# Rezoning Transportation Analysis

Petition Number: 2022-146

## Revision Log:

Date	Description
1-25-23	First Review (IW)
04-19-23	Second Review (IW)

<p>Issue Date: 12-21-22</p> <p>Project Number: 199.005</p> <p>Sheet 1 of 1</p>	No.	Date	Description	1	3-10-23		2	1-10-23				
No.	Date	Description										
1	3-10-23											
2	1-10-23

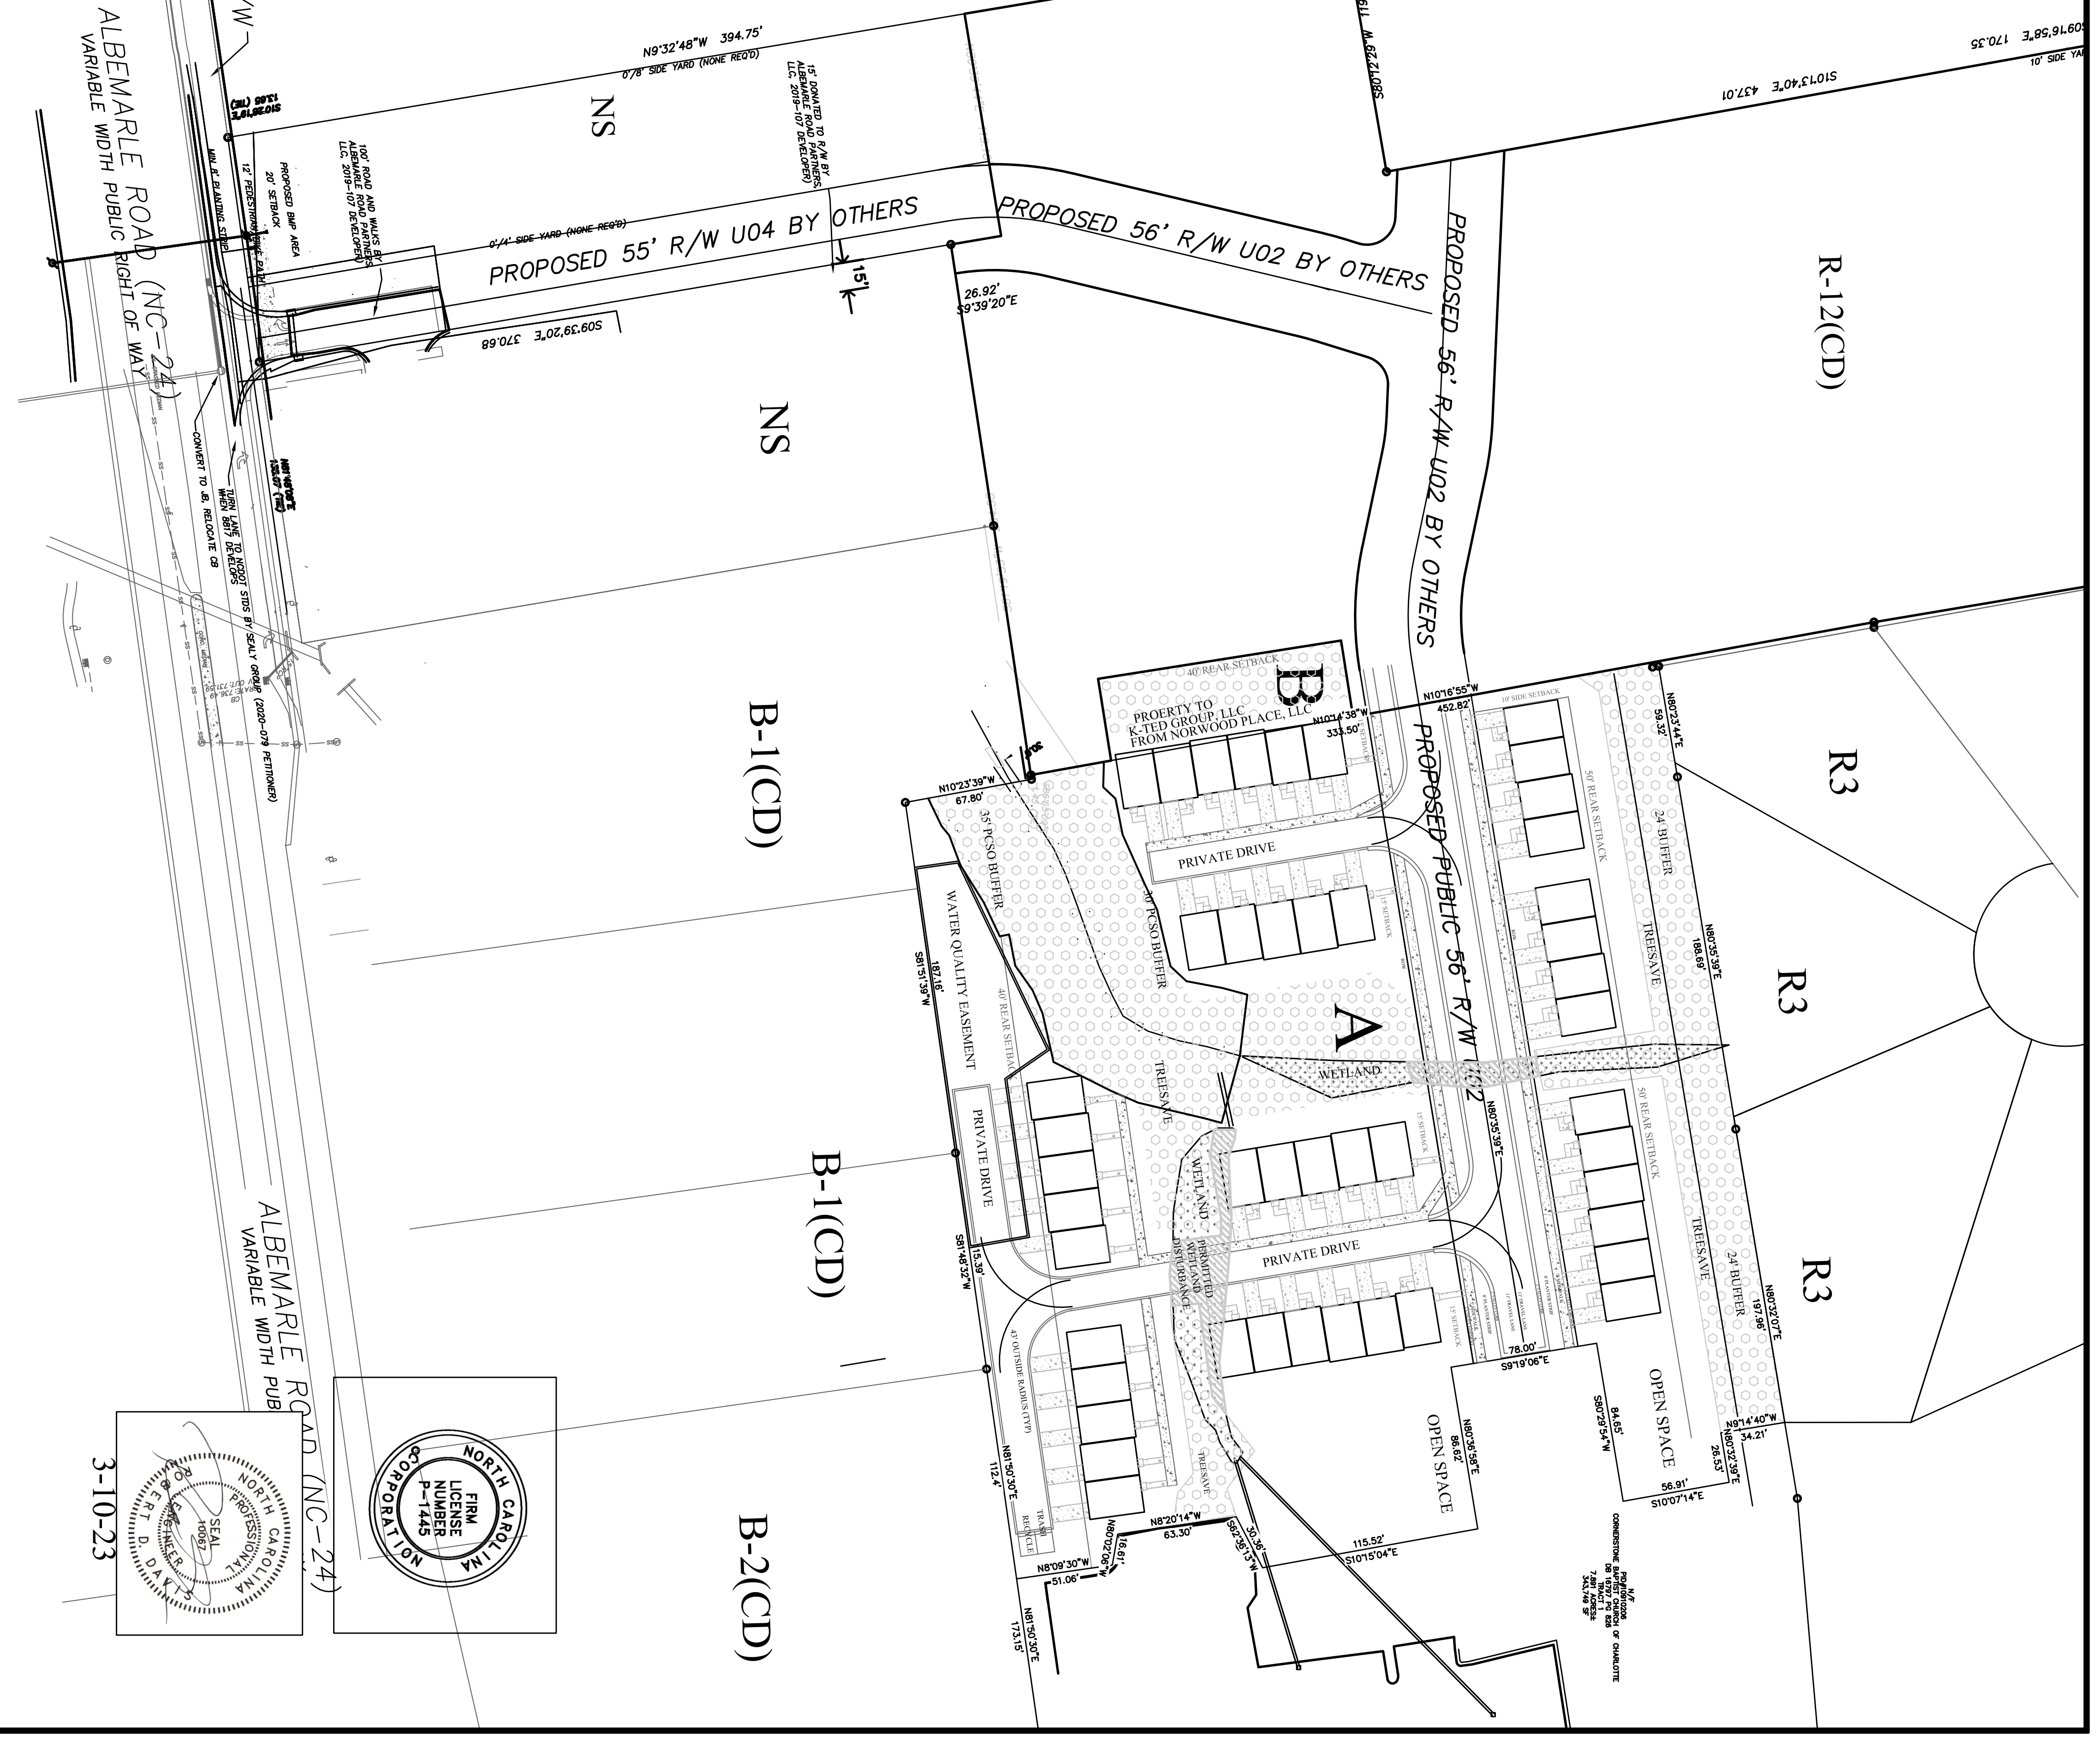
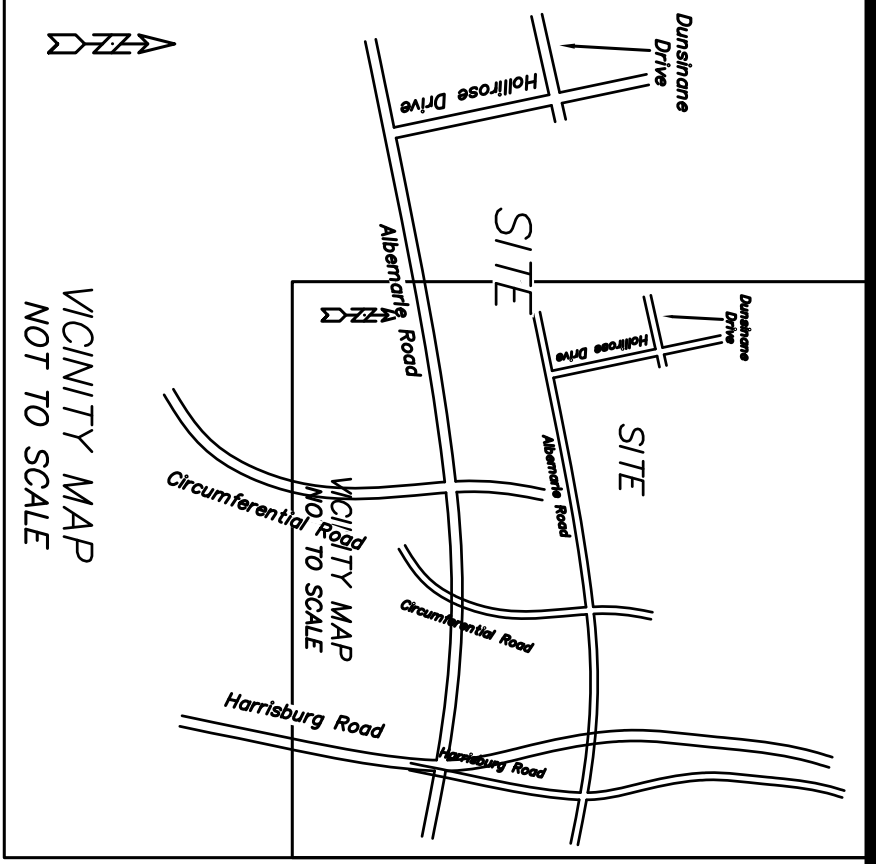
3. Revise site plan and conditional note(s) to commit to construct an 8-foot planting strip, and 5-foot sidewalk on Dusinane Extension per Chapter 20. The site plan shall label and dimension both items from the back of curb and gutter or edge of pavement.

**Clarifying Comment 4-20-23:** Update conditional notes to commit to constructing Dusinane as a U02 and constructing the 8 foot planting strip and 5 foot sidewalk.

5. Add a conditional note specifying “A Right-of-Way Encroachment Agreement is required for the installation of any non-standard item(s) (irrigation systems, decorative concrete pavement, brick pavers, etc.) within a proposed/existing City-maintained street right-of-way by a private individual, group, business, or homeowner’s/business association. An encroachment agreement must be approved by CDOT prior to construction/installation. Contact CDOT for additional information concerning cost, submittal, and liability insurance coverage requirements.”

6. Add a conditional note specifying “the Petitioner shall dedicate and convey in fee simple all rights-of-way to the City before the site’s first building certificate of occupancy is issued. CDOT requests rights-of-way set at 2’ behind back of sidewalk where feasible.”

7. Add a conditional note specifying “All transportation improvements will be approved and constructed before the site’s first building certificate of occupancy is issued. The petitioner may phase transportation improvements if said improvements and phasing are explicitly described in site plan notes.”
